DSU - DEVELOPMENT ADVISORY PANEL RECORD OF MINUTES

1. Date and time of Meeting 10 April 2014

4. Development proposal Proposed Cold Storage warehouse & distribution facility.

SWIRE COLD STORAGE, MARSDEN PARK
SWEPT PATH ASSESSMENT
32.1m SUPER B-DOUBLE

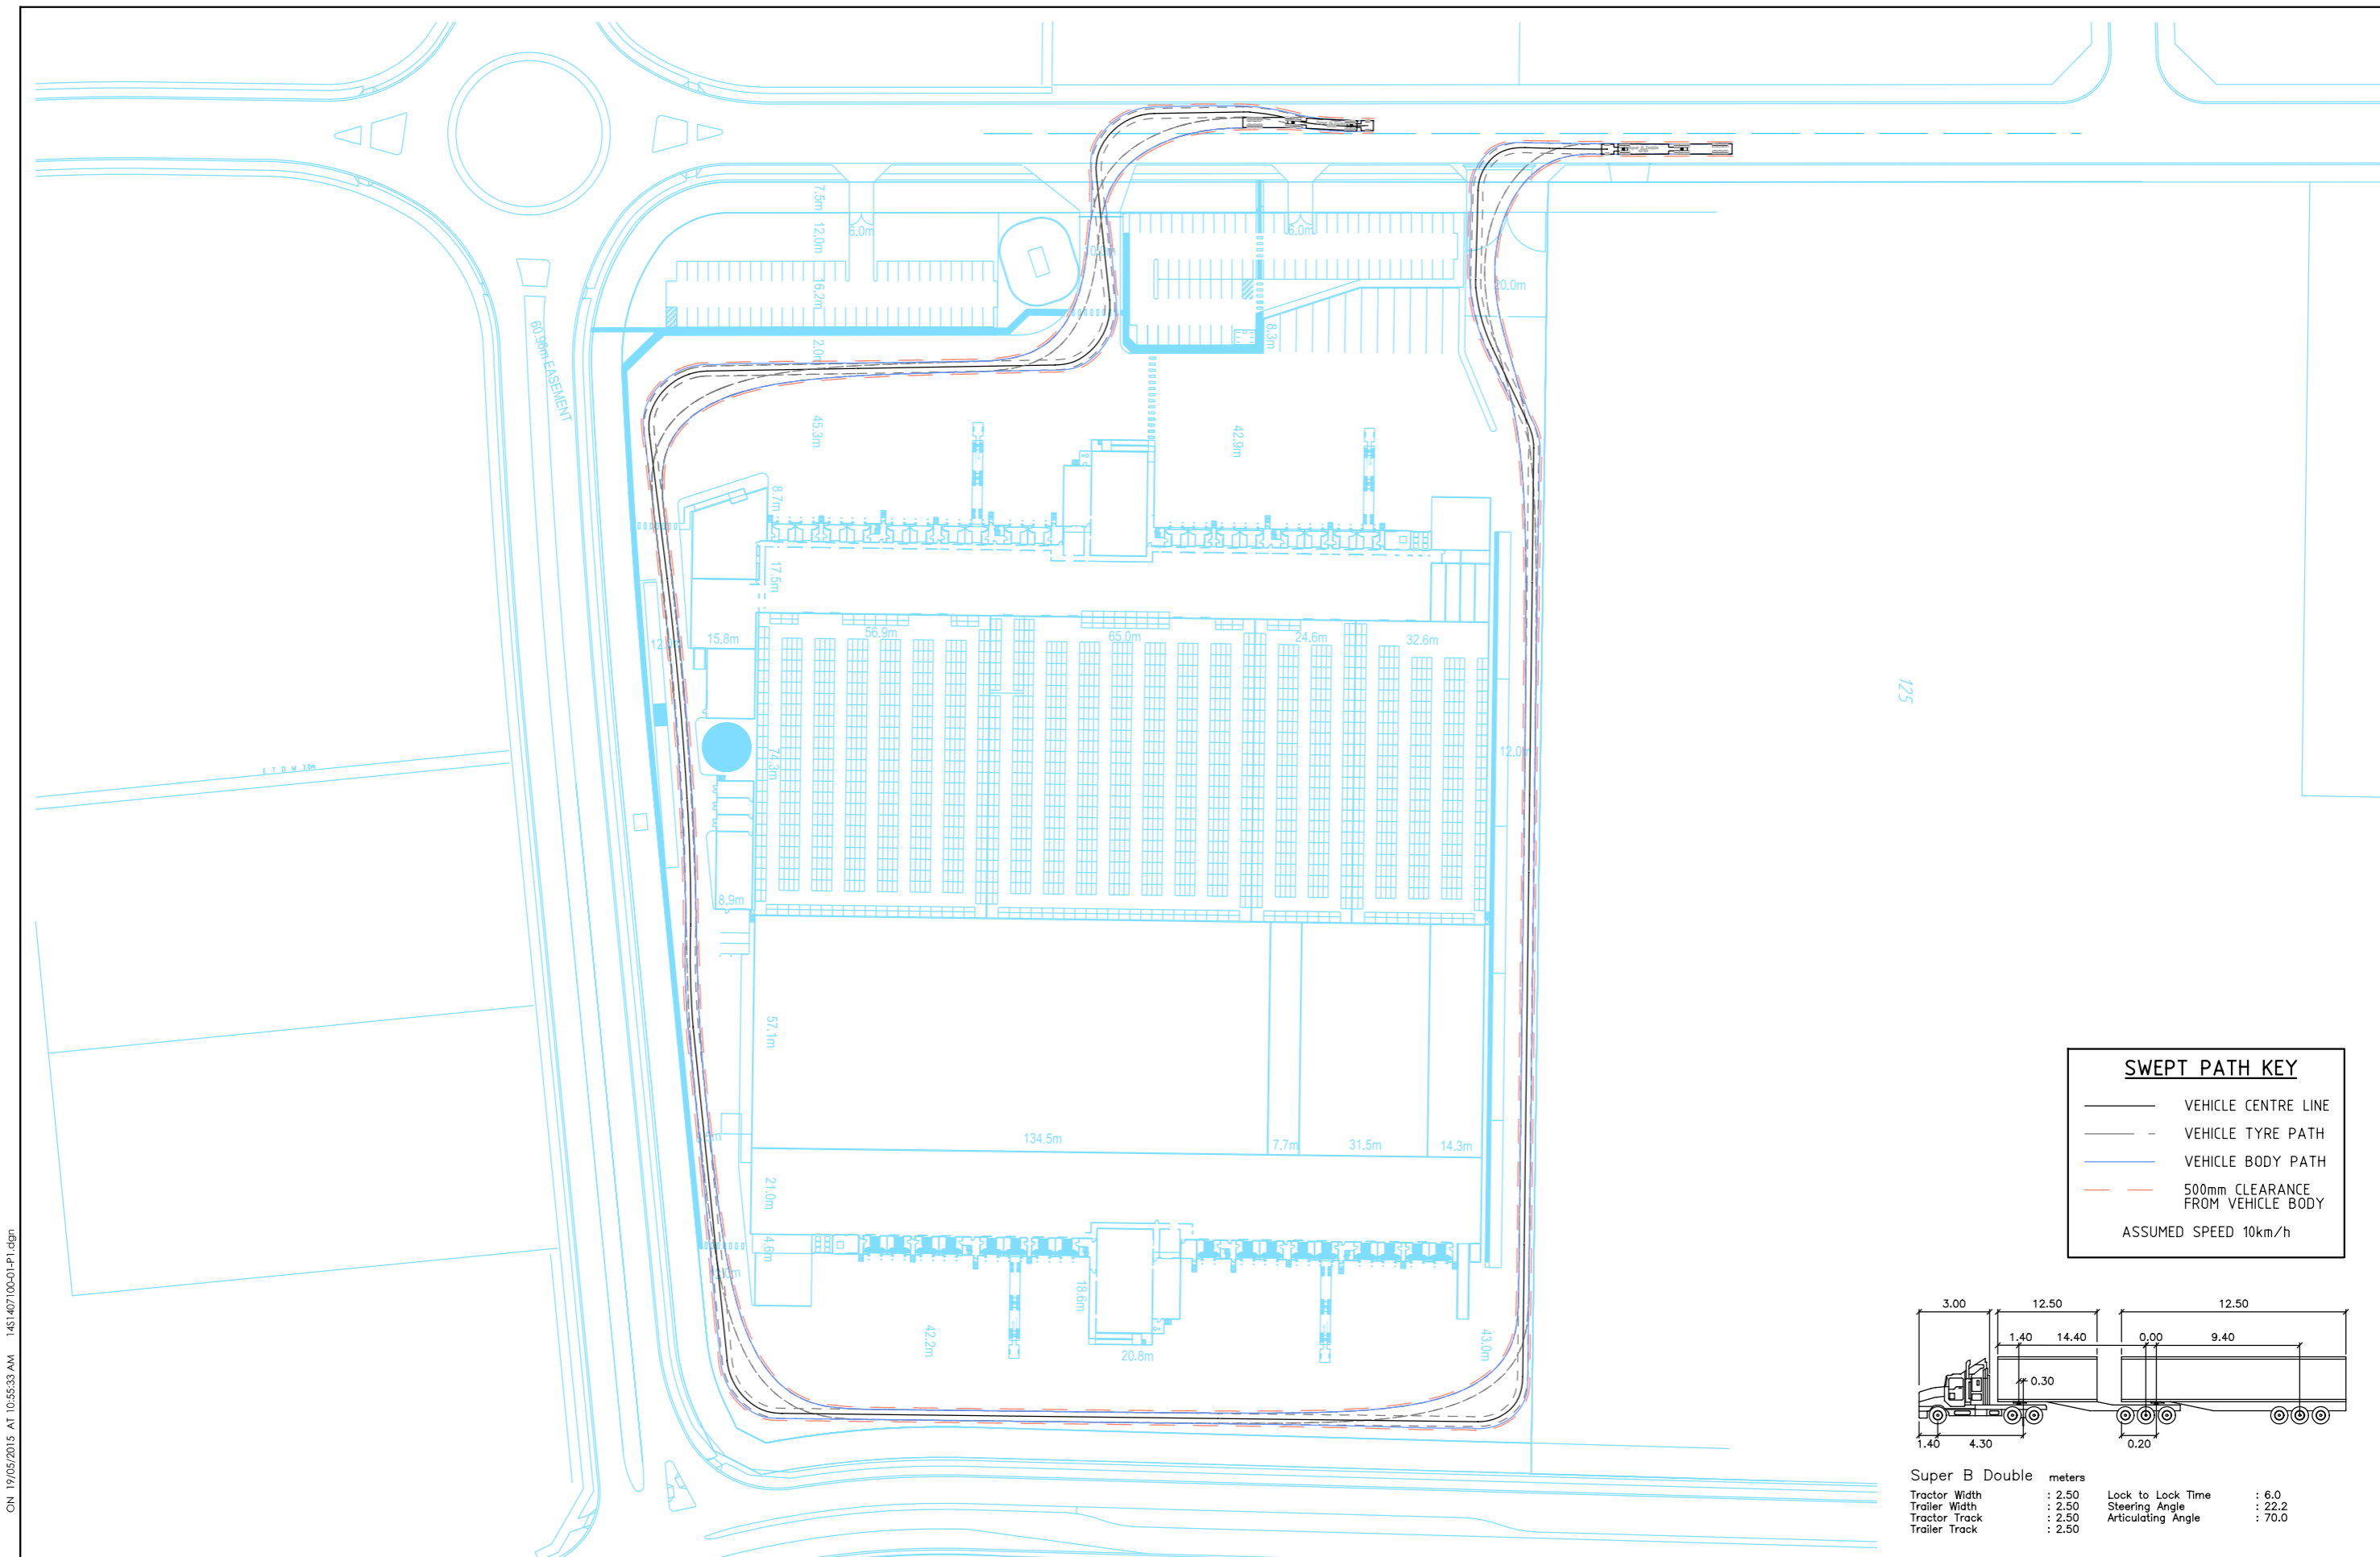
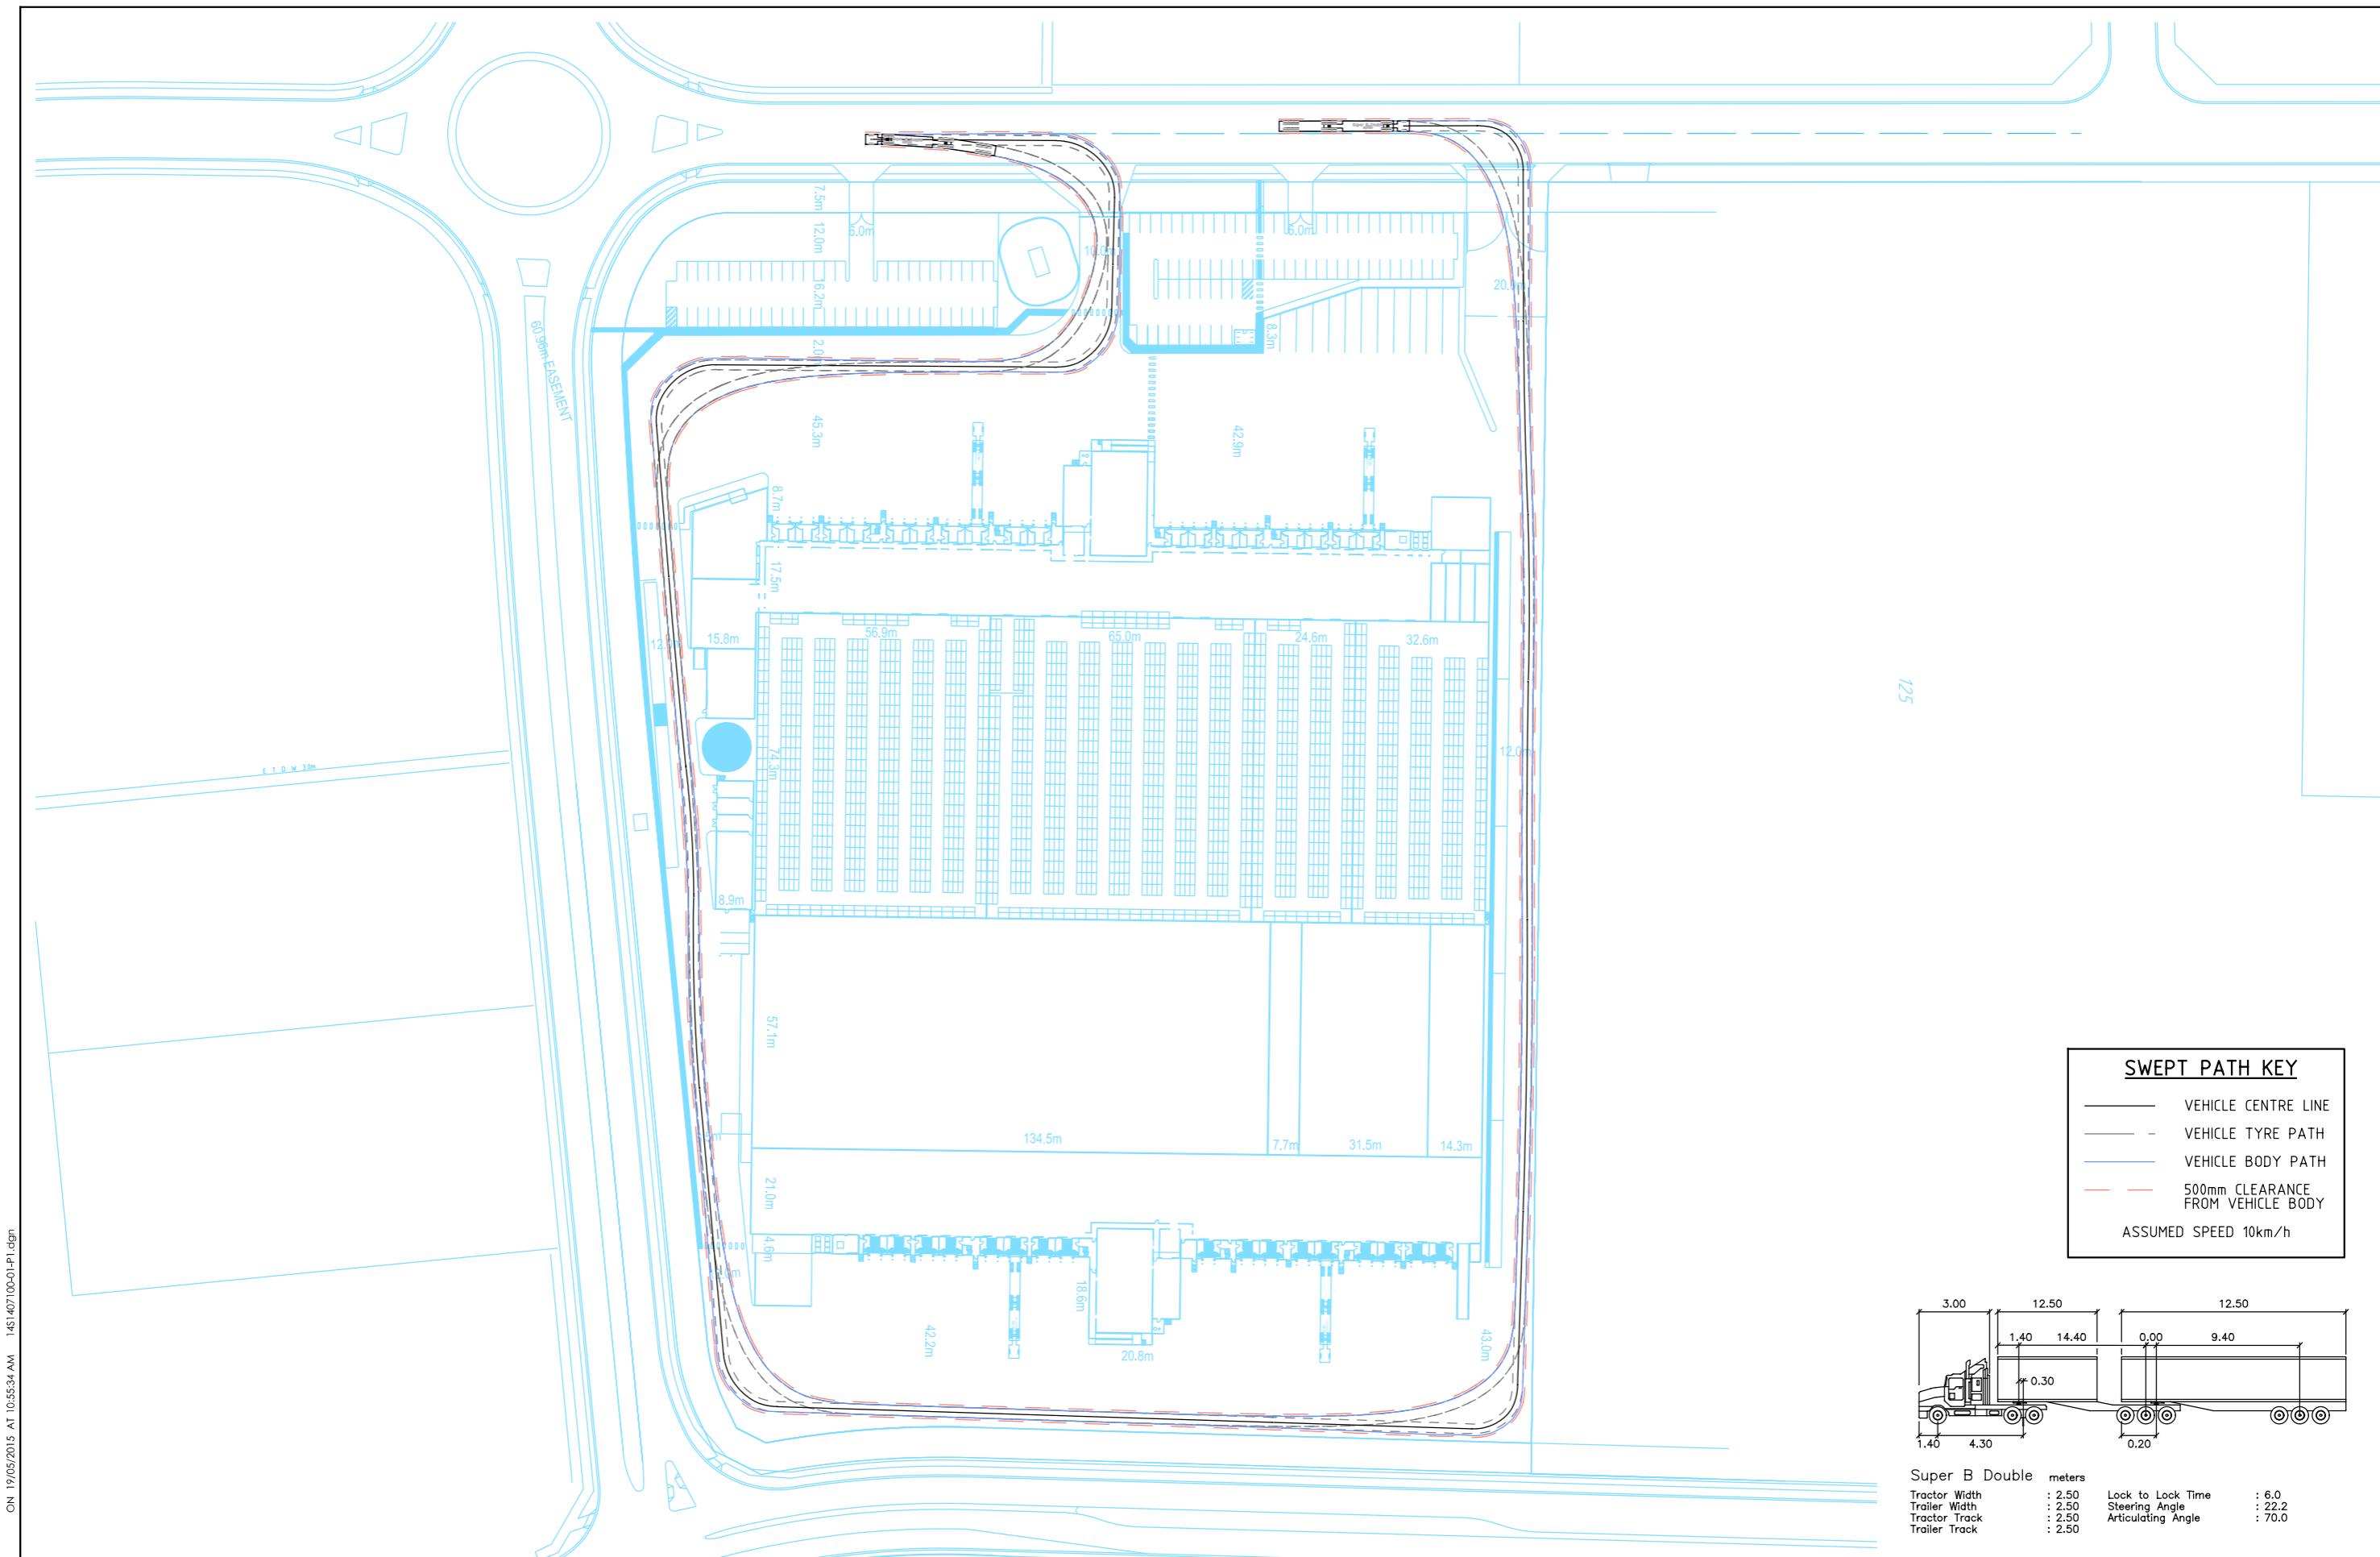
Applicant needs to show all the sweptth paths into /out of the site & demonstrate how super B-double type trucks (on the understanding that the development will

be serviced by these) can enter site without travelling into the other traffic lanes - needs to stay in its own traffic lane.

Photomontage - View from Richmond Rd / Hollinsworth Rd Intersection

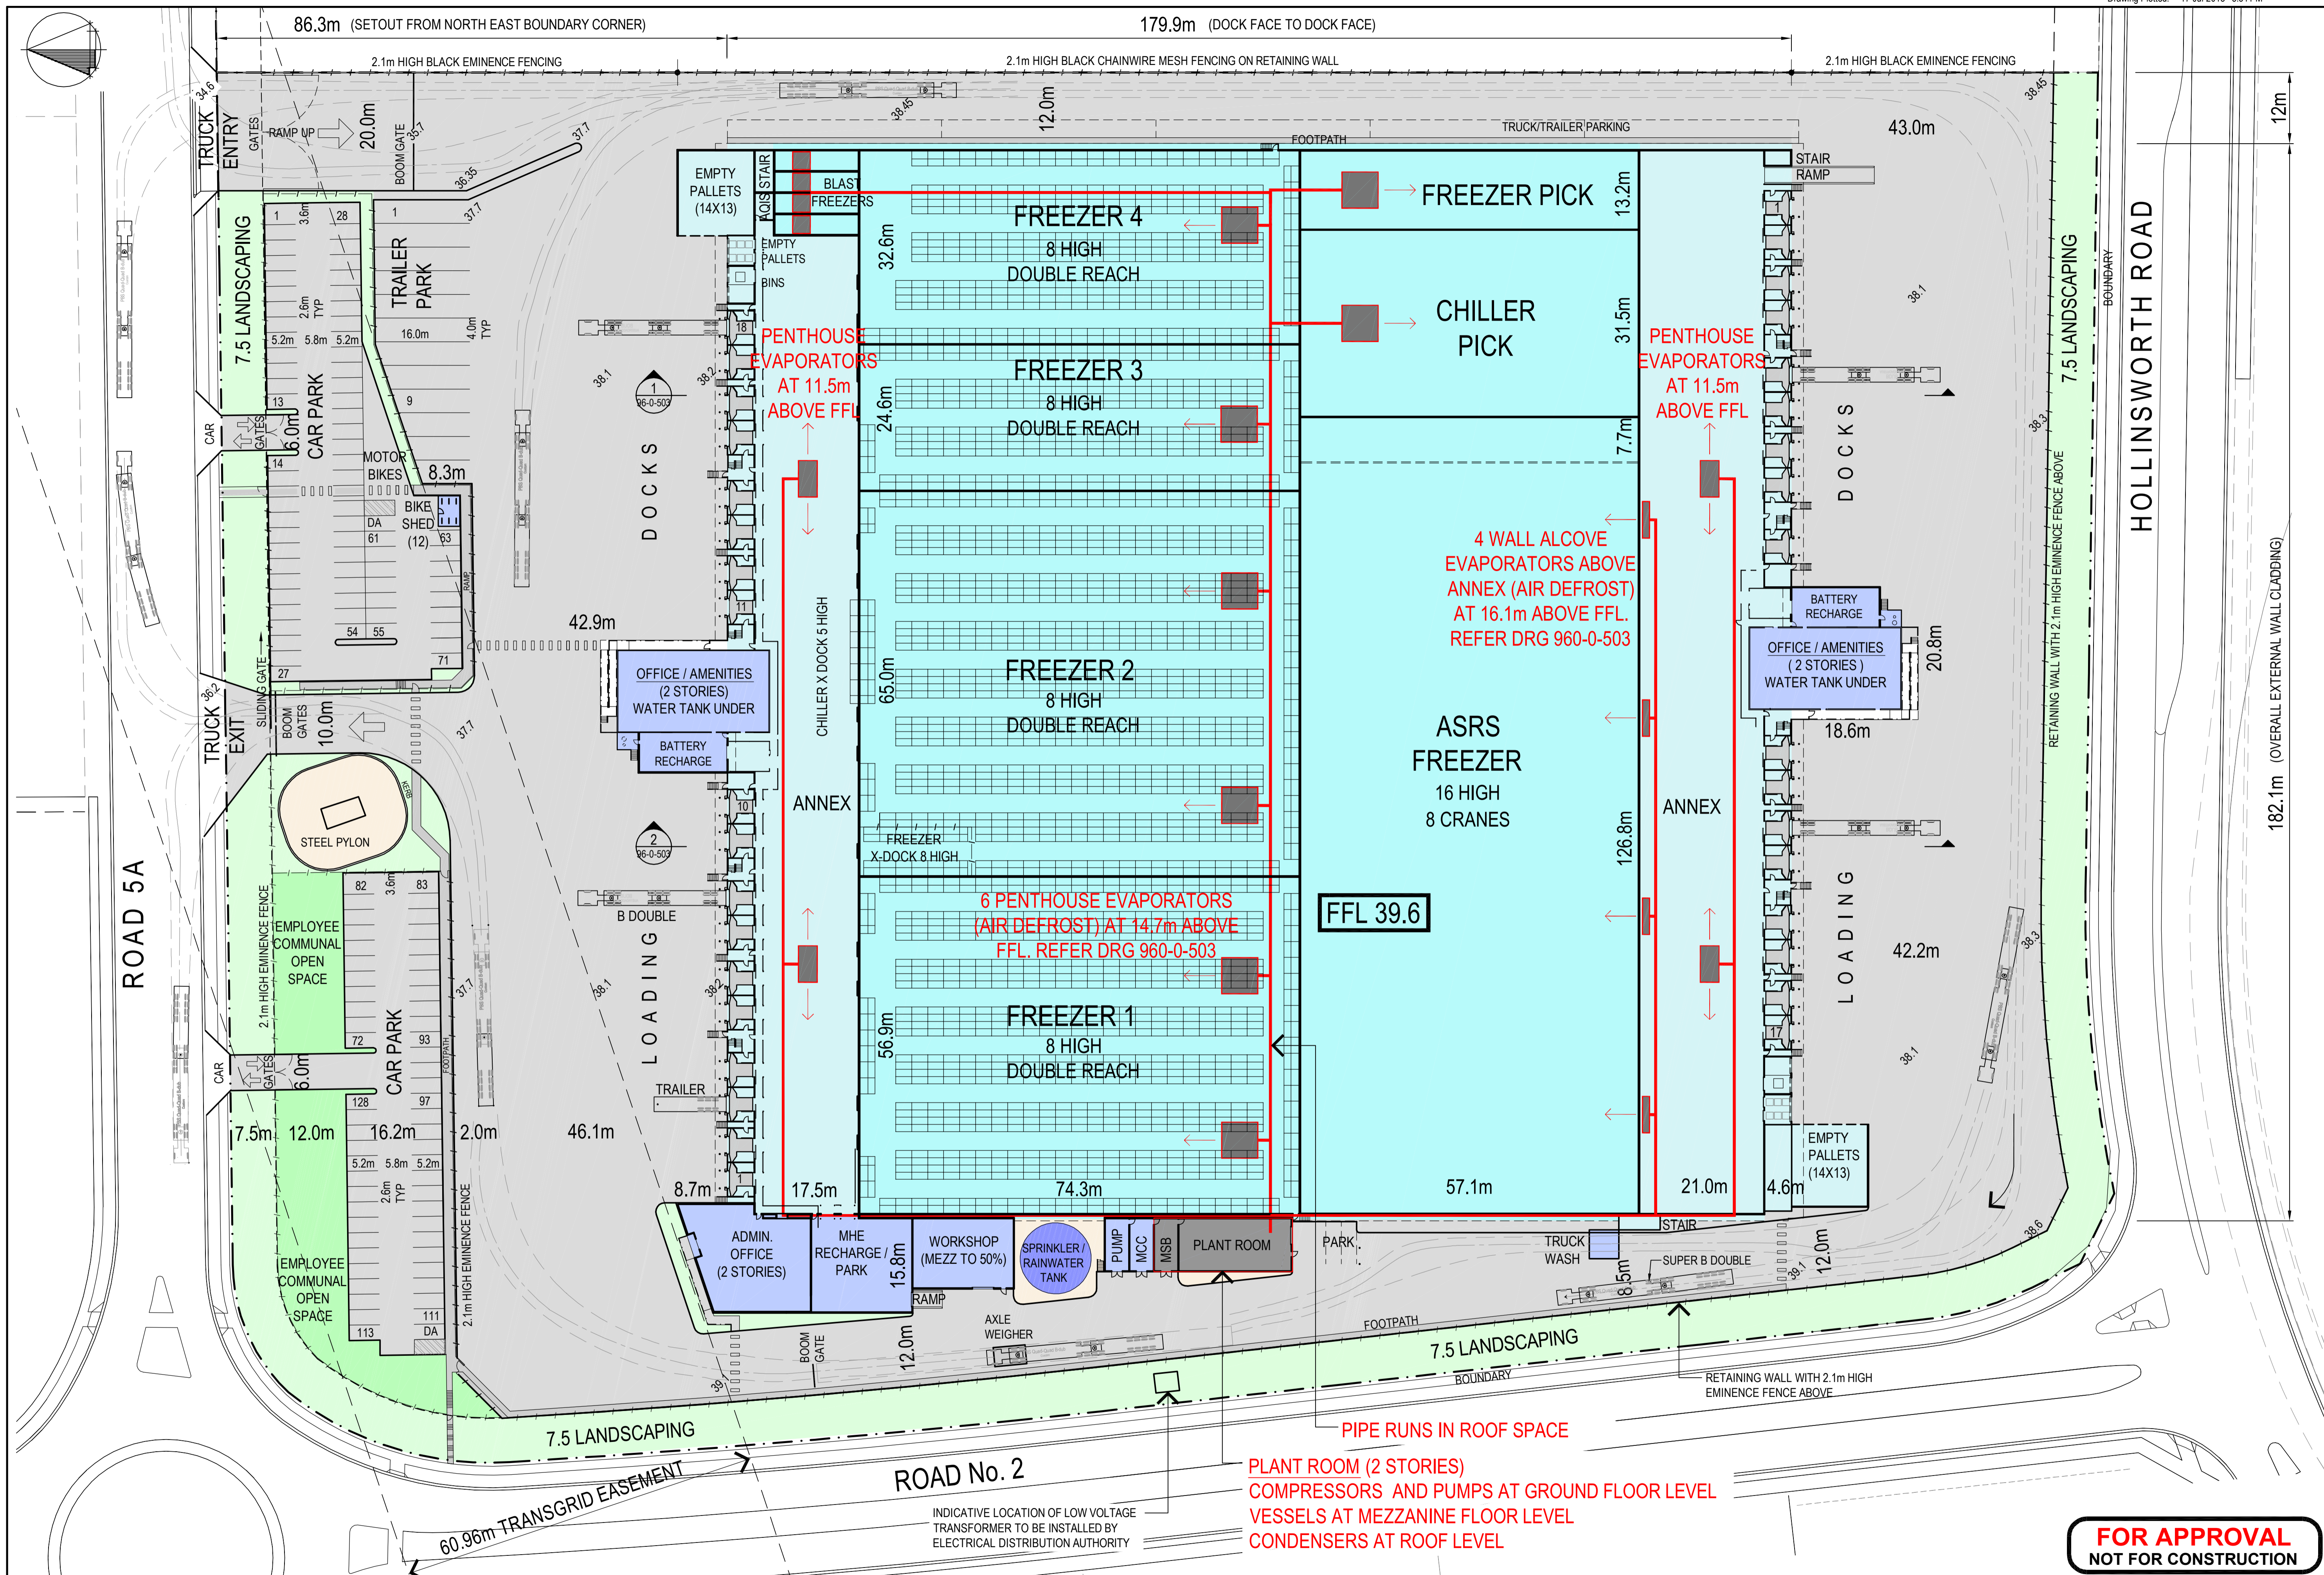
Ensure attractive external appearance - not blank walls
Provide photo montage to be submitted with the DA that show its appearance from all streets in its context.
Need to provide the ~~the~~ landscaped setback requirements set out in the Precinct Plan for the Marsden Park Industrial Estate. No carparking can encroach the required ~~the~~ setbacks.
